From: Tom Errico <thomas.errico@tylin.com>
To: Helen Donaldson <HCD@portlandmaine.gov>
CC: David Margolis-Pineo <DMP@portlandmaine.gov>, Katherine Earley <KAS@portlandmaine.gov>, Jeremiah Bartlett <JBartlett@portlandmaine.gov>, Jeff Tarling <JST@portlandmaine.gov>
Date: 10/28/2015 6:59 PM
Subject: 158 Fore Street - Preliminary Traffic Comments

Nell - I have reviewed the application materials and offer the following preliminary traffic comments.

**SPACE AND BULK STANDARDS**

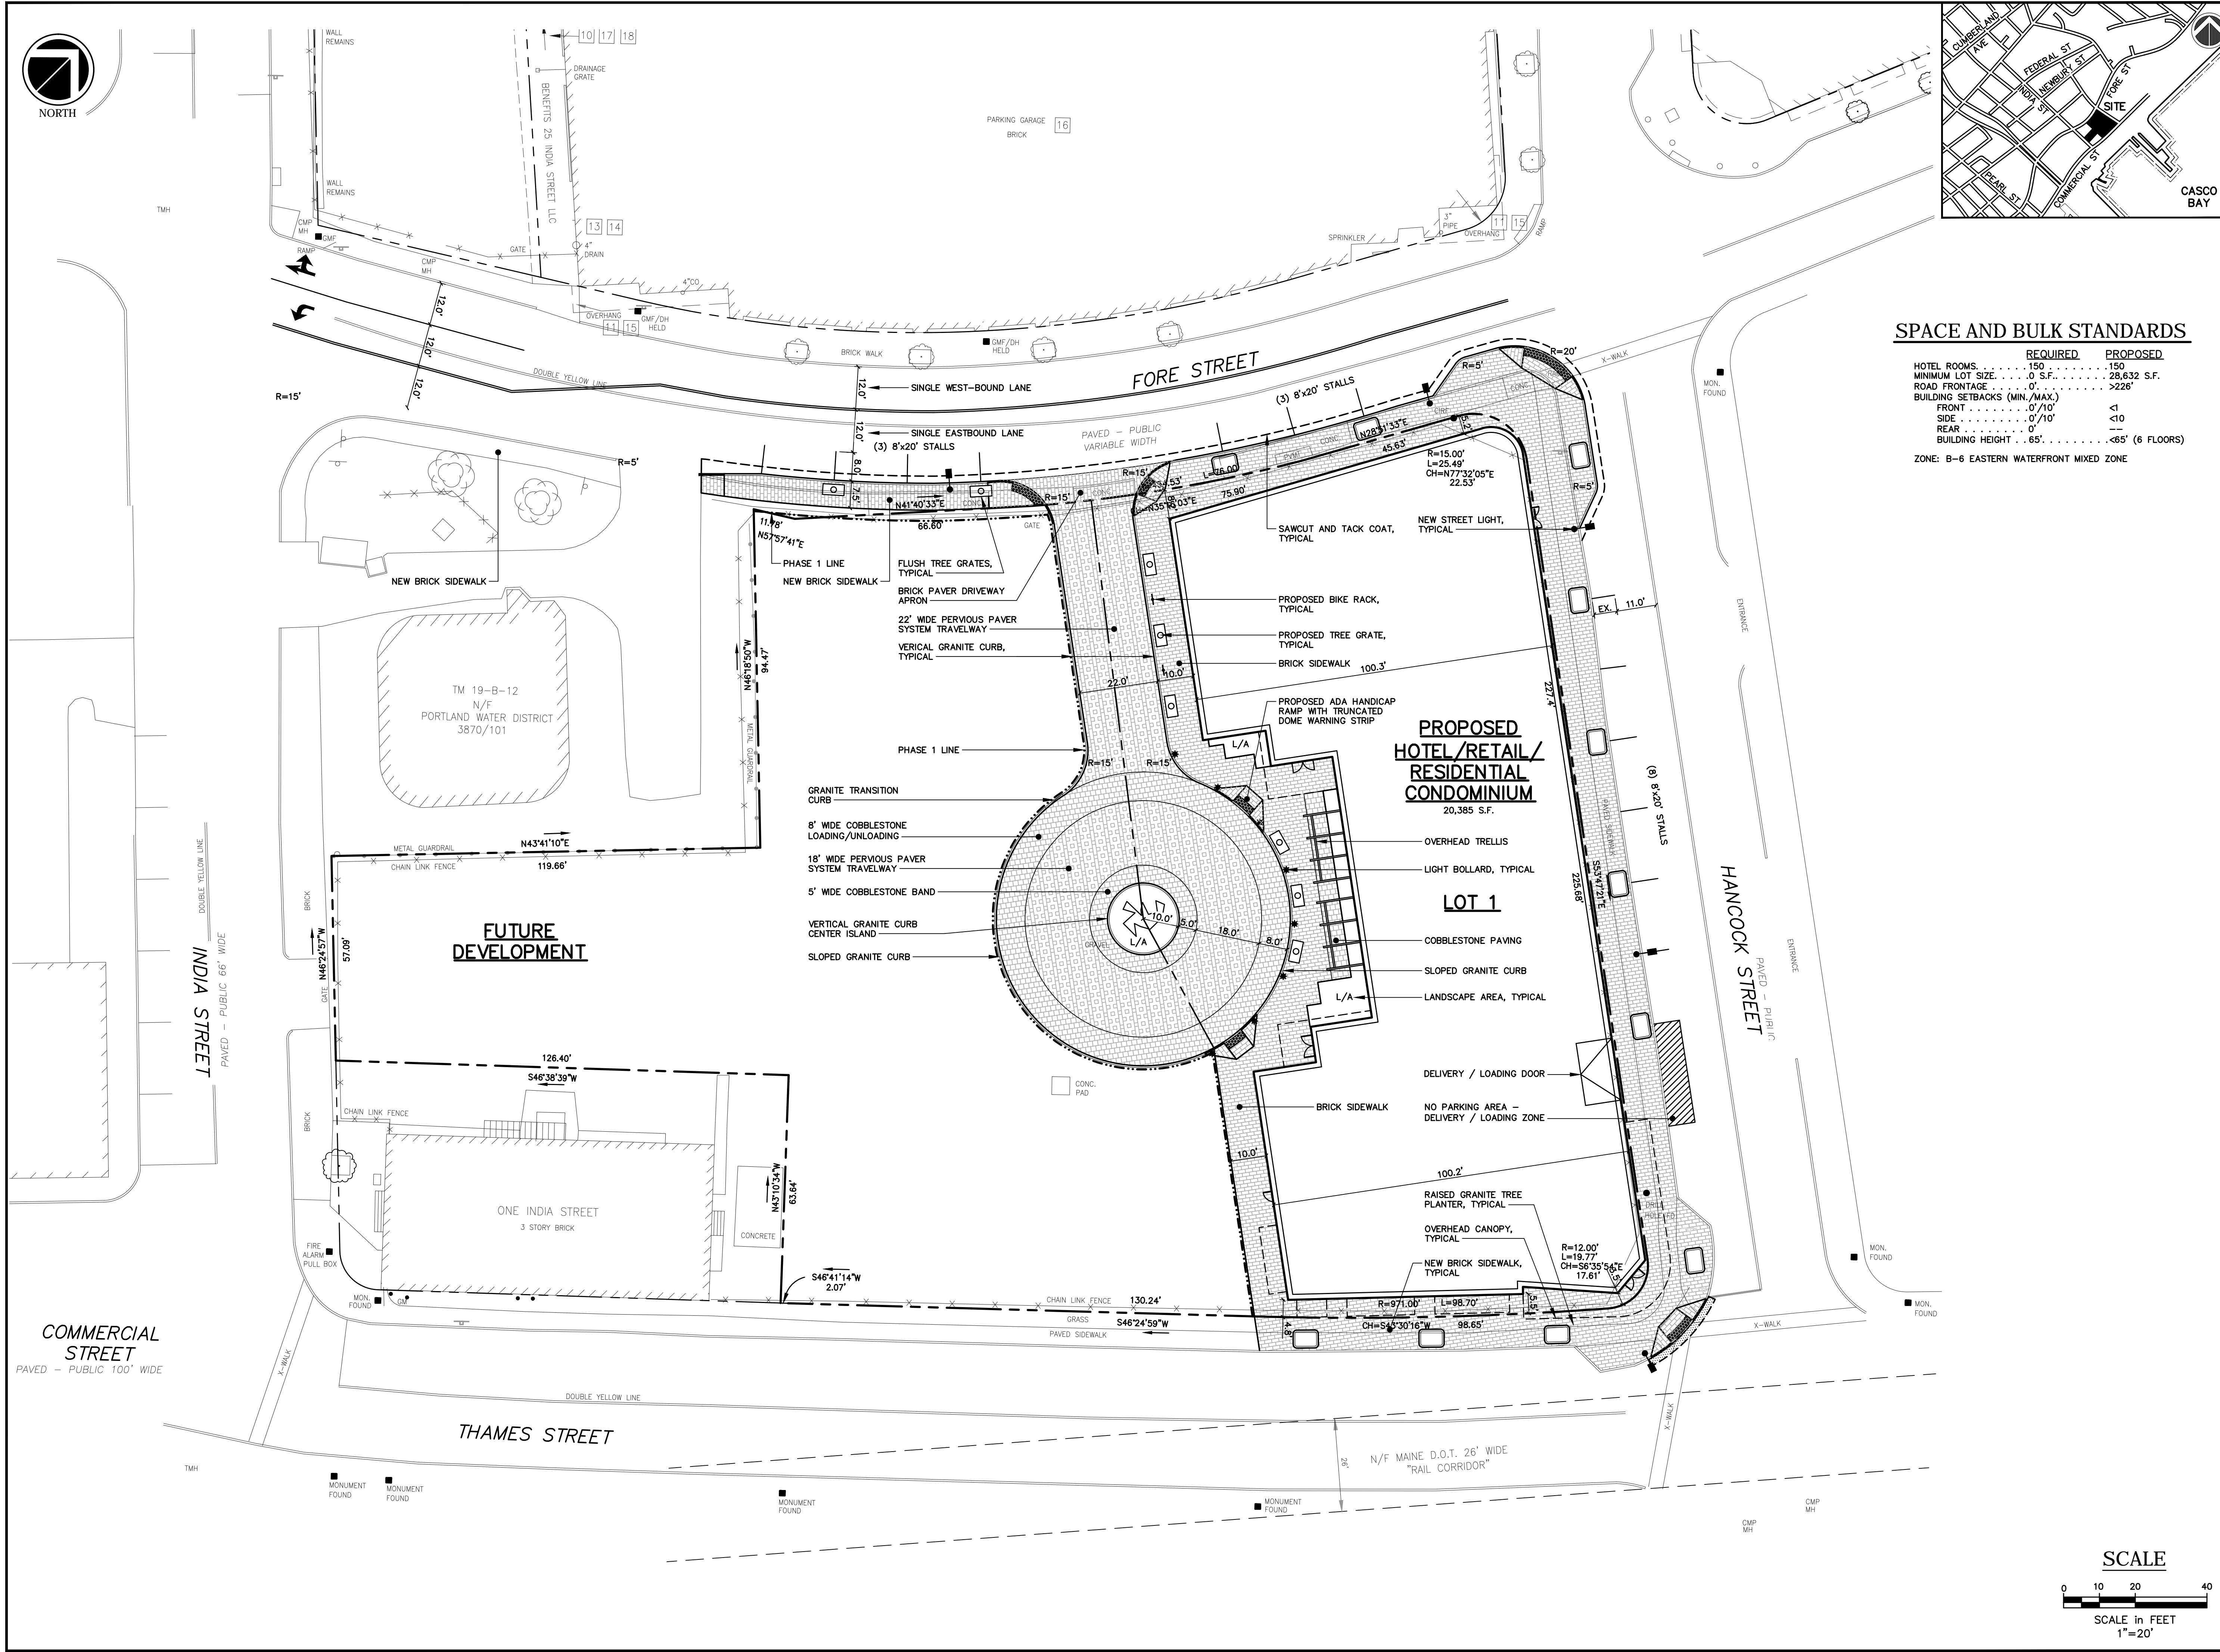
- * Specific details on deliveries shall be provided. The painted detail on Hancock Street should be eliminated. I will coordinate with the Parking Division on sign regulations.

- * Detectable warning panels are not required at the site driveway. I would suggest tip-down curbing for improved sidewalk slope conditions.
- * The application indicates that a Fore Street improvement plan will be provided. I will review the plan upon receipt.

- * Please note that the on-street parking stalls are not to include painted lines separating spaces. This should be noted on the plan.
- * Pedestrian use easements will be required for the sidewalk on Fore Street.

- * I will coordinate with the Parking Division and DPS on Fore Street on-street parking regulations.
- * I need to further review the configuration of the corner handicapped ramps to ensure optimal compliance.

- * The driveway apron material does not meet City design standards and I will refer this issue to DPS.
